DELEGATED DECISION TO DETERMINE PLANNING APPLICATIONS

Reference No:	2025/62/91146/E
Site Address:	112, Hopton Lane, Upper Hopton, Mirfield, WF14 8JP
Description:	Erection of rear extensions and raising of ridge to form first floor habitable accommodation with associated internal and external works
Recommending Officer:	Faiza Bano

OFFICER REPORT

STATUS		PROJECT TITLE	
PLANNING DRAWING		HOPTON LANE	
DRAWING TITLE		SITE SECTIONS	
SCALE	DRAWN	CHECKED	PROJECT REFERENCE
1:200	EG	JH	ODS 24/911
PAPER SIZE	DWG NUMBER	DATE	REVISION
A2	(70)001	02/10/24	/
CLIENT		MR S HARRISON

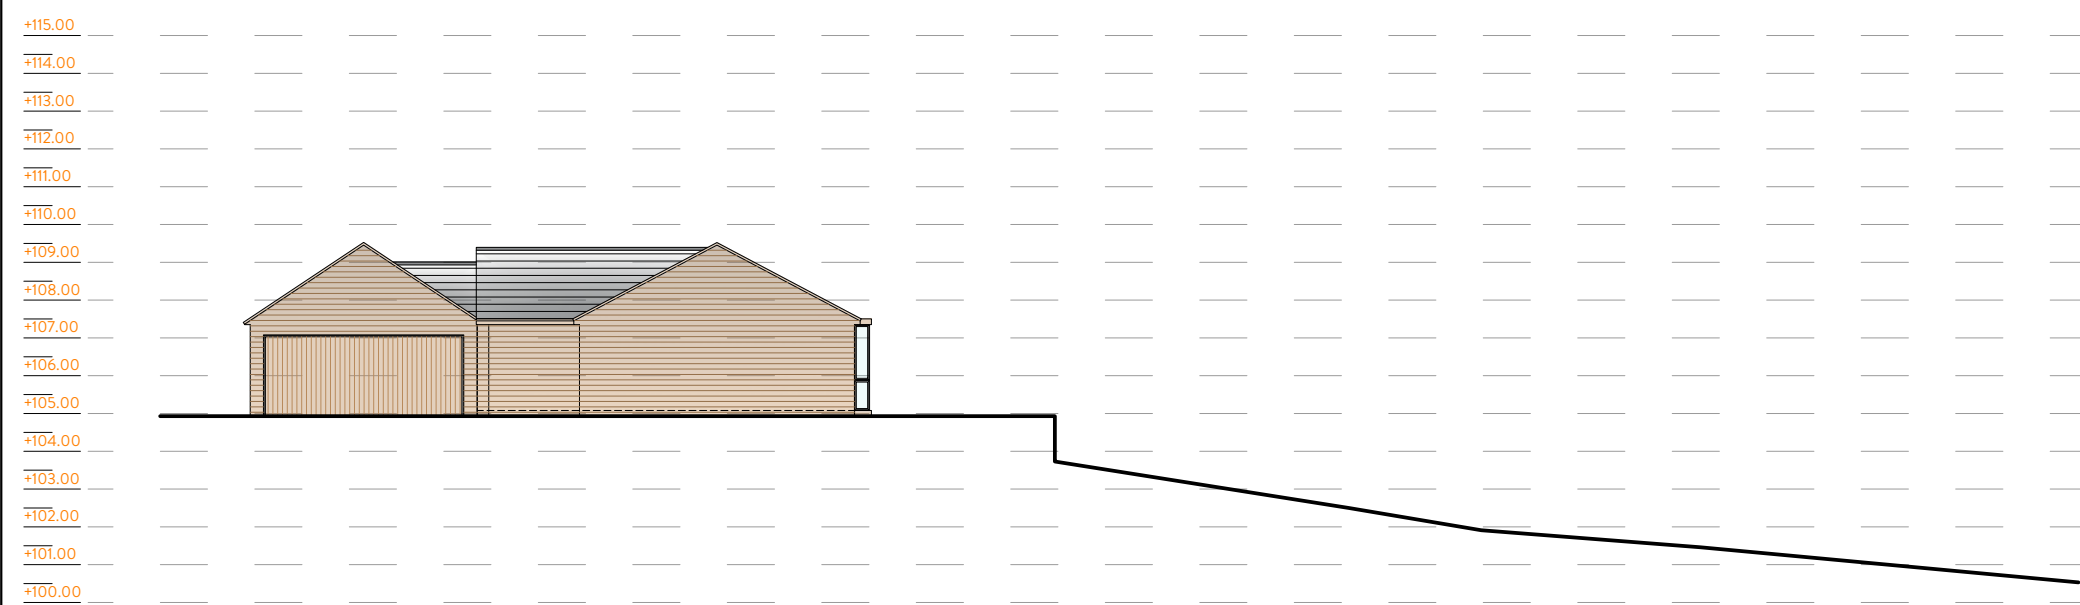
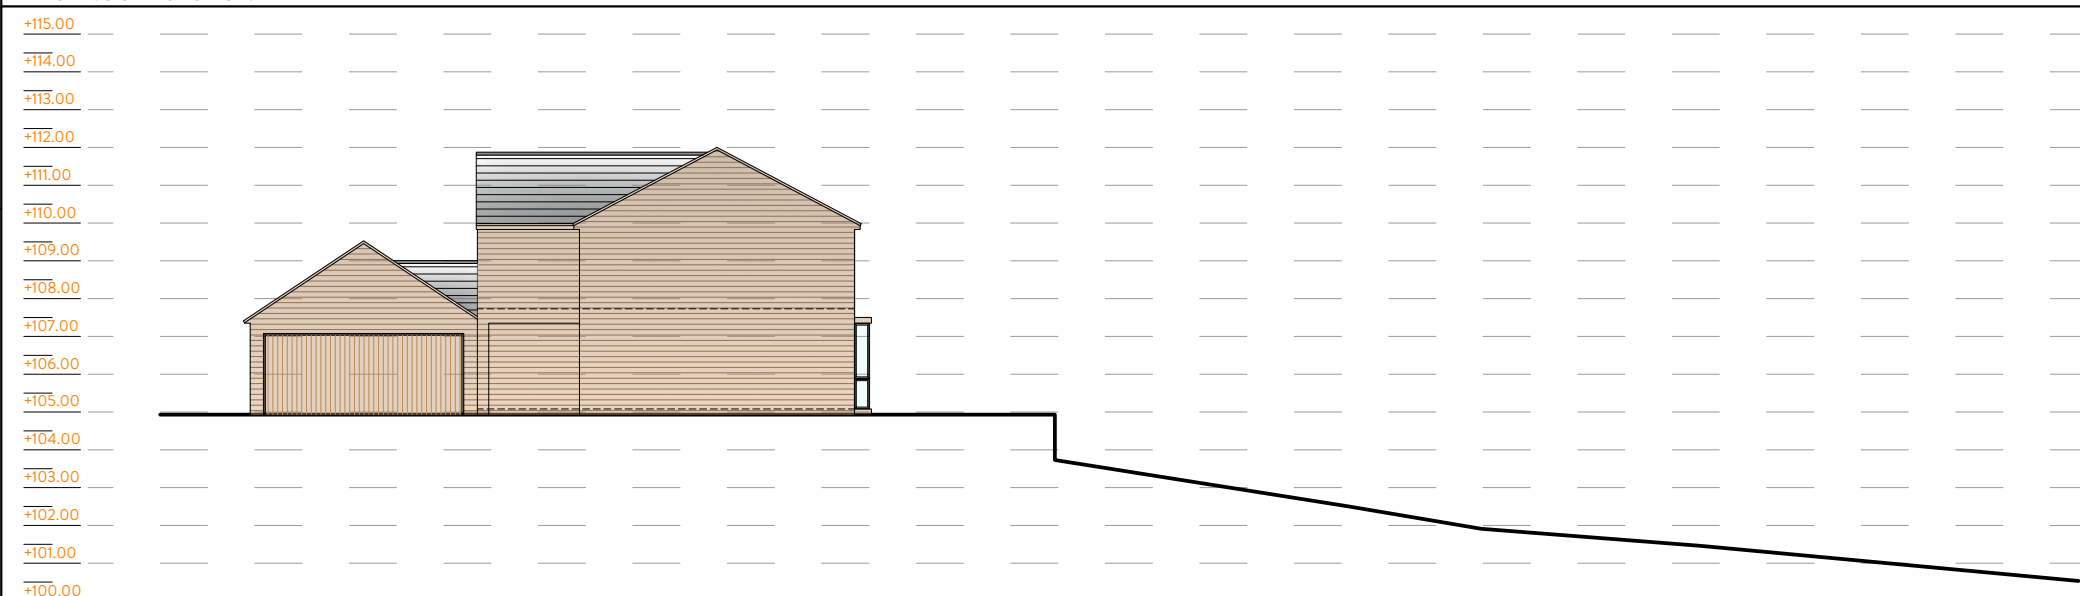
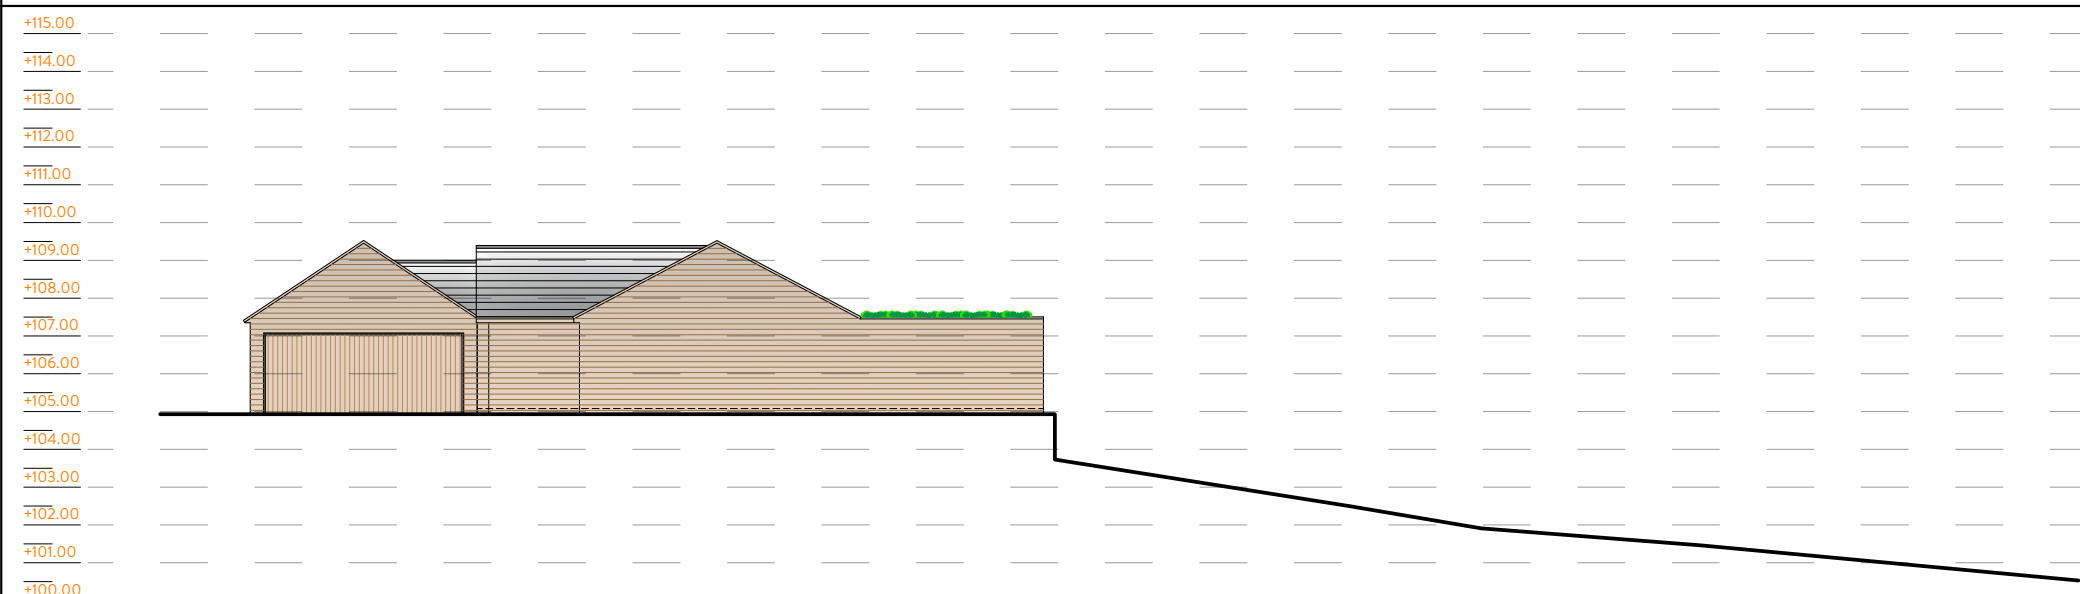
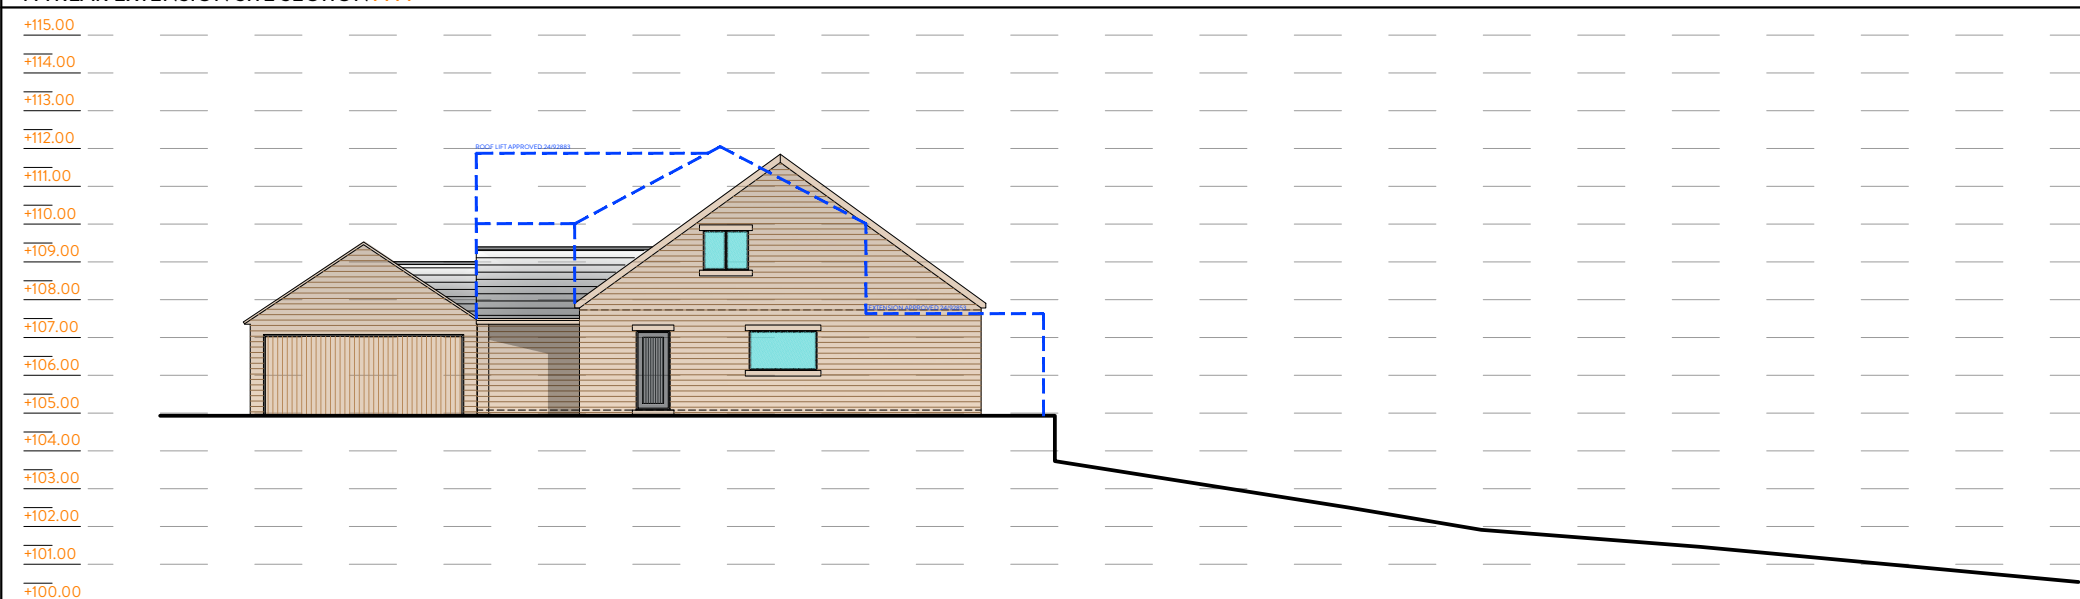
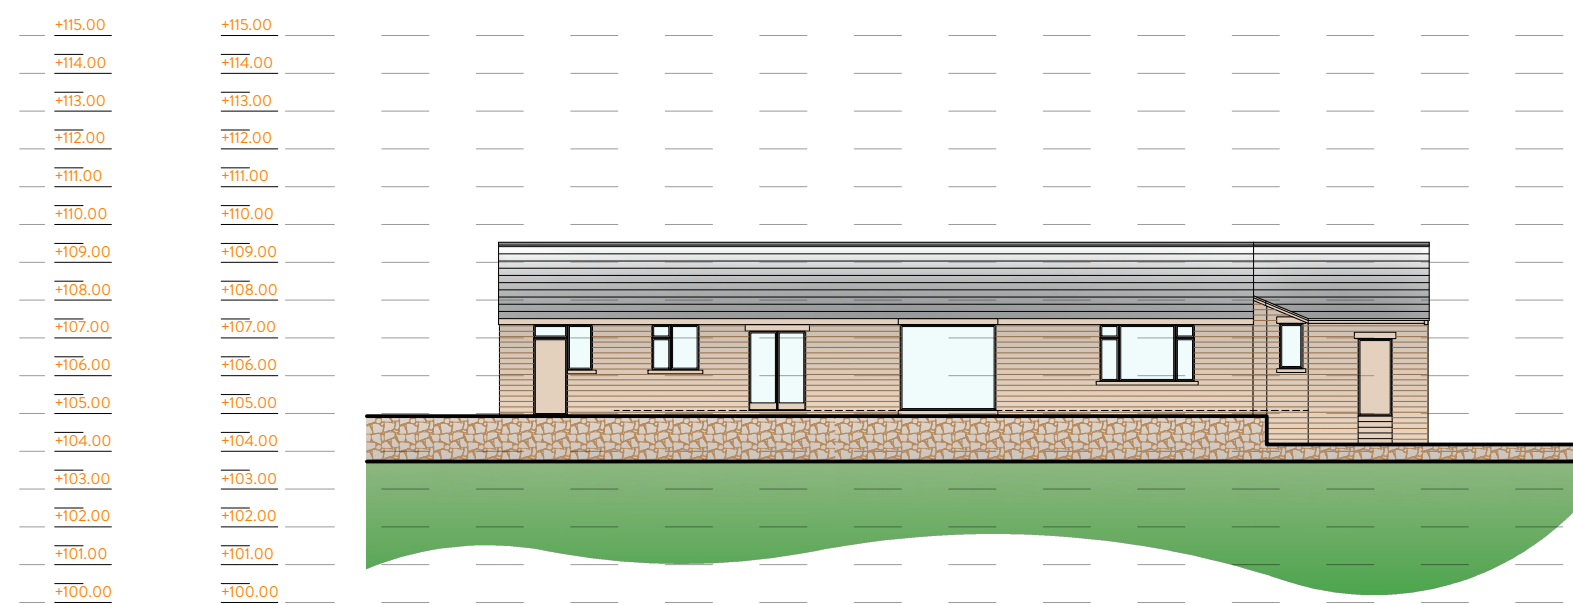
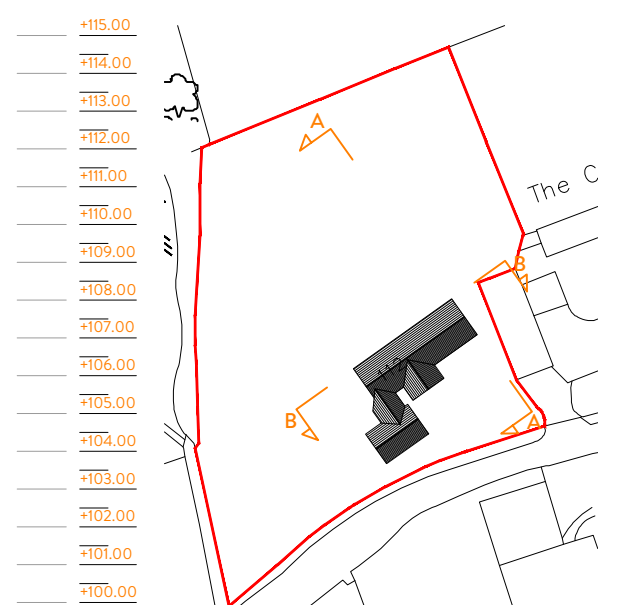
The scheme the subject of the previous refusal has since been revised such that rather than having a lower ground element which is visible above ground level, this would now be a purely subterranean element and the dwelling would be viewed as a two storey dwelling from the rear rather than three storey as the refused scheme had the appearance of previously. The appearance of the proposal would be closer, in design terms to that of the previously consented permitted development schemes and therefore it is considered weight is able to be afforded to those previously consented schemes.

The proposed increase in roof height remains below the previously approved fallback position and will not significantly alter the character of the bungalow. The visibility of the basement level was a factor contributing to the refusal of the previous application; however, it is considered that this application addresses the visibility issue and is now deemed acceptable. The scale of the works is not considered to be excessive following the revisions the subject of this application taking account of the open setting and has reduced the level of additional urbanising bulk, form, and massing into the location.

This conclusion is drawn on the basis the subterranean element is below ground level, and that a finished ground levels condition is included as part of any grant of permission to ensure this is the case.

5. The development shall not be brought into use until a scheme of finished ground levels has been submitted to, and approved in writing by, the Local Planning Authority. The submitted scheme shall detail the finished ground levels surrounding the dwelling to ensure the subterranean level is below ground level. The submitted scheme shall detail corresponding existing and finished ground levels and of surface and land drainage associated with any works. The development shall not be brought into use until the approved scheme has been completed and which shall be retained thereafter.
